REPORT TO: NSW Department of Planning & Environment

**SUBSIDENCE REVIEW
– Russell Vale Colliery Residual Matters Report
Independent Peer Review**

REPORT NO: 1407/02.1

DATE: 25th September, 2014

Figure 1: Plan of PPR mining area and previous mining activity.

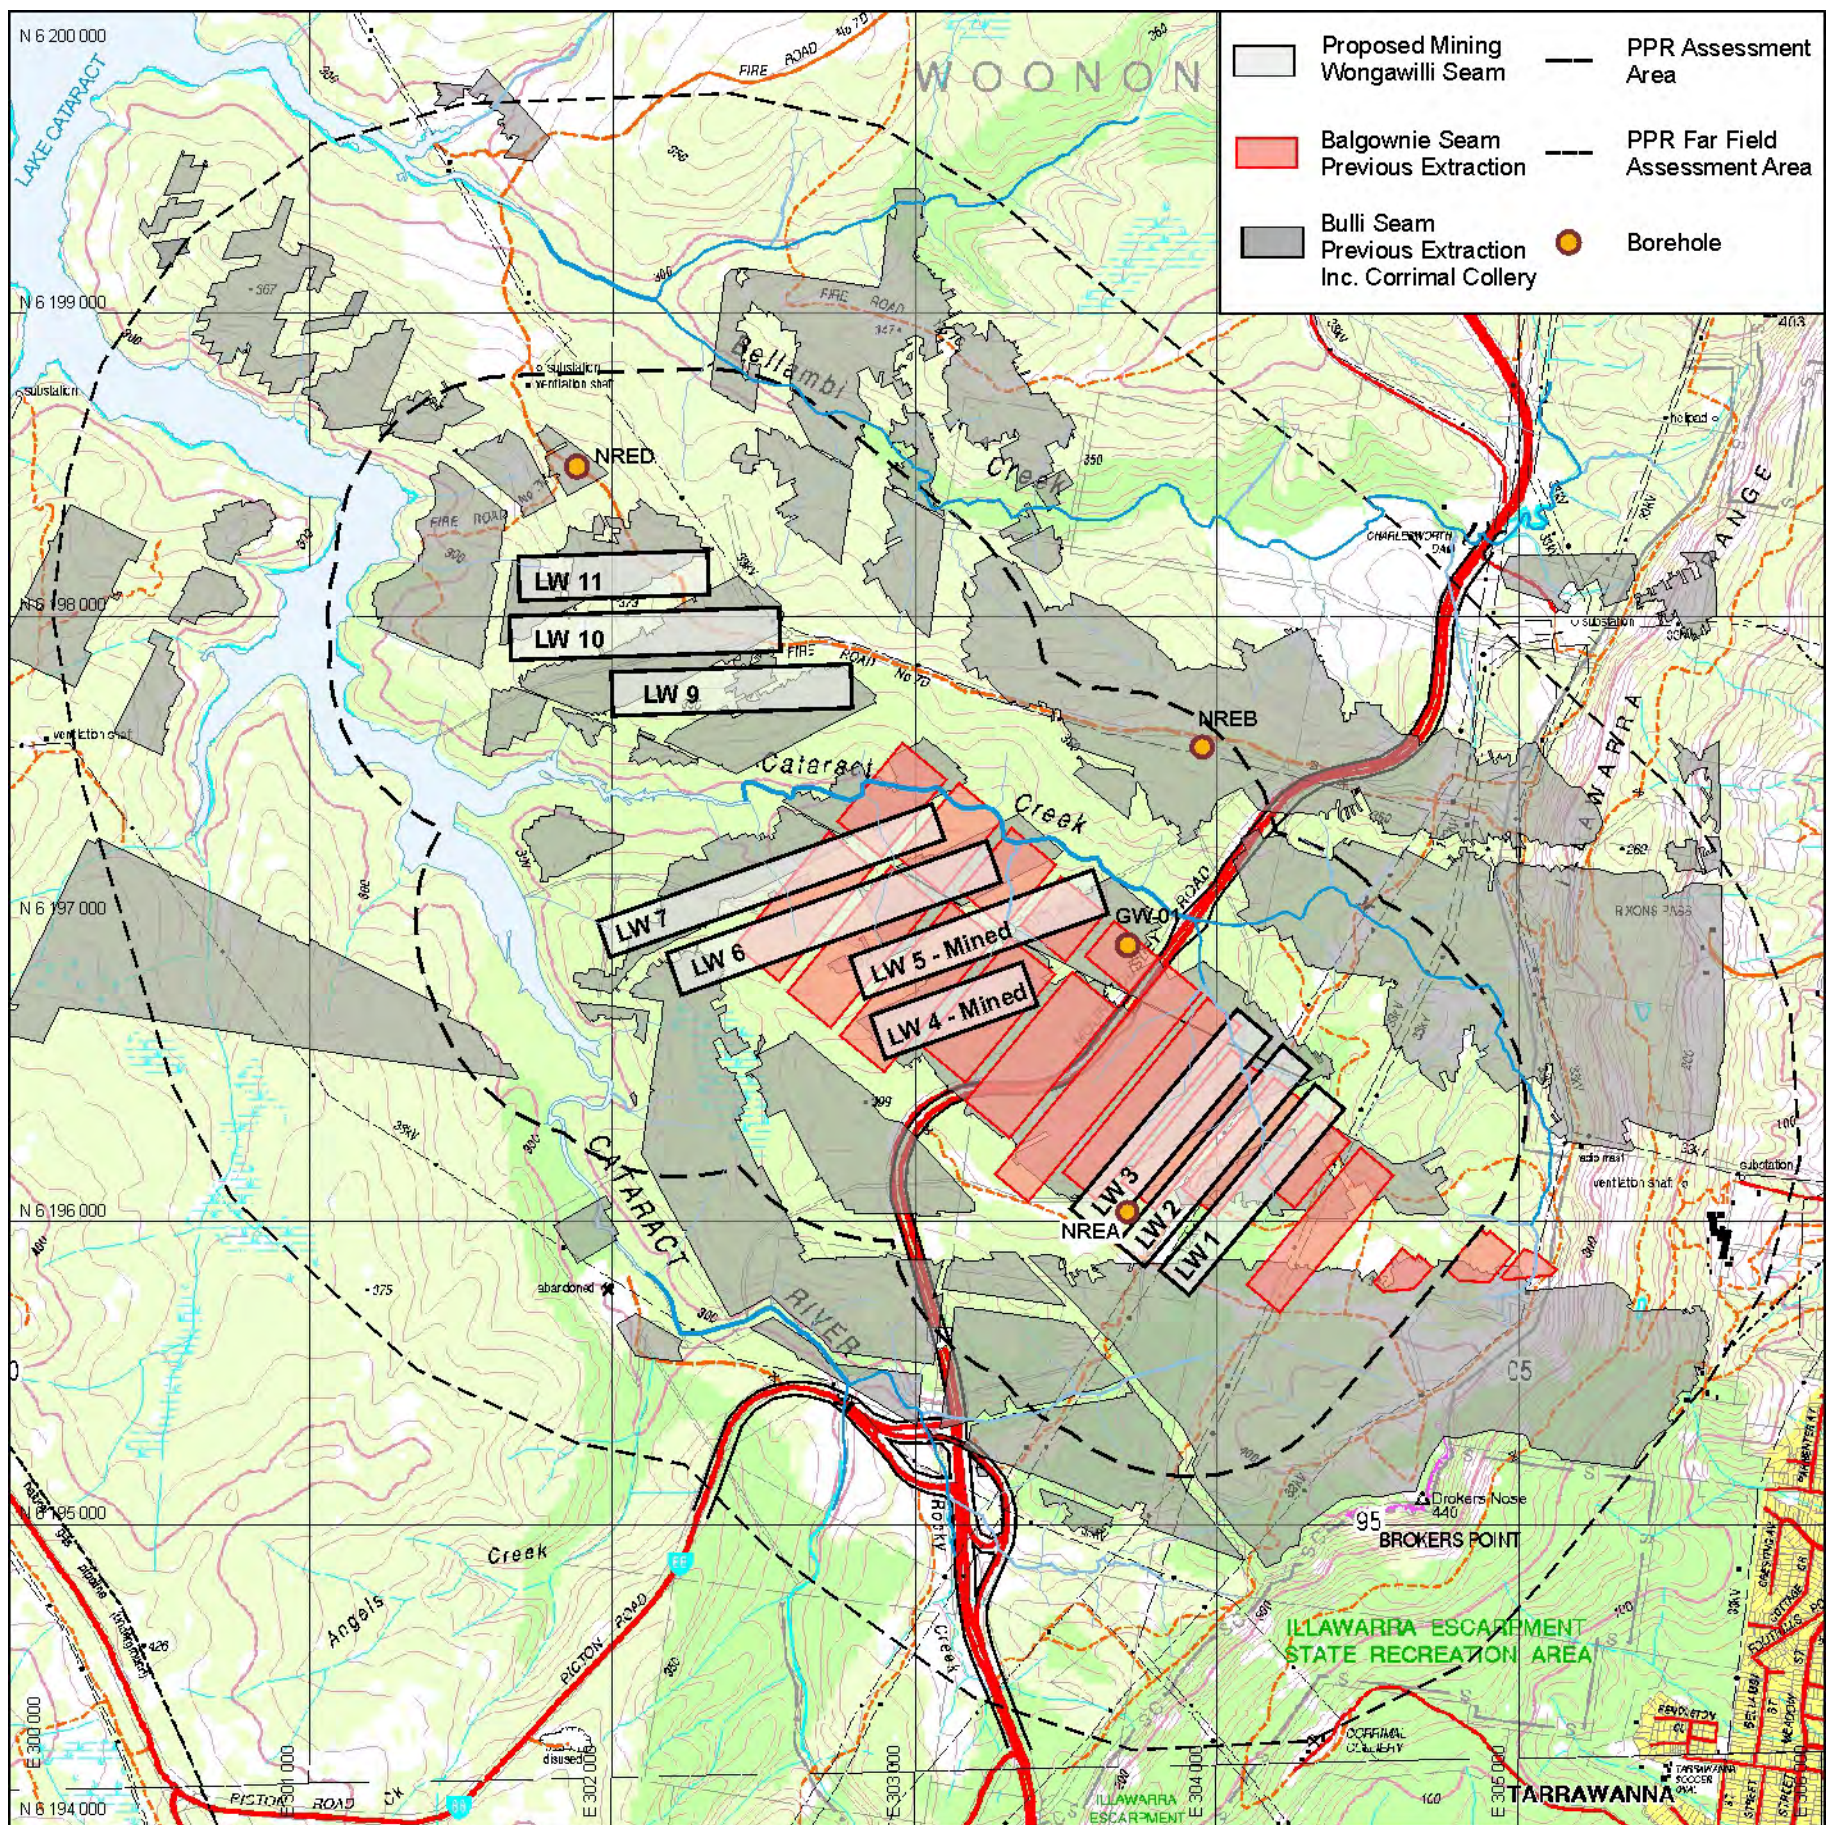
- 4) Summary, p(iii) – There remains some concern expressed by SCT about overlying pillar stability in just one area of the lease, in the vicinity of LW1. This is expressed as:

“There is considered to be some potential for pillar instability in the Bulli Seam to cause additional surface subsidence of up to about 0.5m in localised areas of marginally stable pillars when the proposed longwall panels are mined in the Wongawilli Seam. The area likely to be most affected by pillar instability is located at the northern end of Longwall 1 and although the area is relatively small compared to overburden depth, special consideration is required in this area to limit impacts on power transmission pylons located nearby”.

This concern should be reflected in adoption of an effective monitoring and adaptive management campaign in this location.

- 5) Summary, p(iii) and p(v) – A range of predicted subsidence values, tilts and strains are provided in the Summary. There are also updated predictions of valley closure in the vicinity of Cataract Creek, as follows:

“The predicted closures across Cataract Creek have been revised slightly from the earlier report. Total closures are predicted to range up to 300mm adjacent to the end of Longwall 5 and up to 290mm adjacent to the end of Longwalls 6 and 7. Closure across the second order southern branch of Cataract Creek upstream of the Mount Ousley Road crossing is predicted to reach 700mm”.

The impacts of valley closure on Cataract Creek should be closely monitored throughout all longwall panel extraction, with a readiness to implement effective adaptive management strategies, should there be any evidence of unacceptable, adverse impacts on the creek bed or valley sides.

In this current report, SCT identifies swamp CCUS4 as one which will undergo a significant level of further subsidence effects.

“CCUS4 has been identified as a significant swamp within the PPR mining area that drains via a first order watercourse. CCUS4 has previously been subsided 0.6-0.8m by mining in the Balgownie Seam without apparent impact. Proposed mining in the Wongawilli Seam is expected to cause up to 2.1m of additional subsidence. Impacts such as cracking of the sandstone base and surface water diversion are expected as a result of proposed mining”.

Provided that the Department is prepared to allow such subsidence effects and potential impacts on this swamp, then this presents an ideal opportunity to gather valuable data on subsidence-swamp interaction. **It should be a requirement for both the subsidence effects, and all resultant impacts to be thoroughly monitored in and around (downstream of) this swamp - before, during and after undermining – for some extended period of time.**
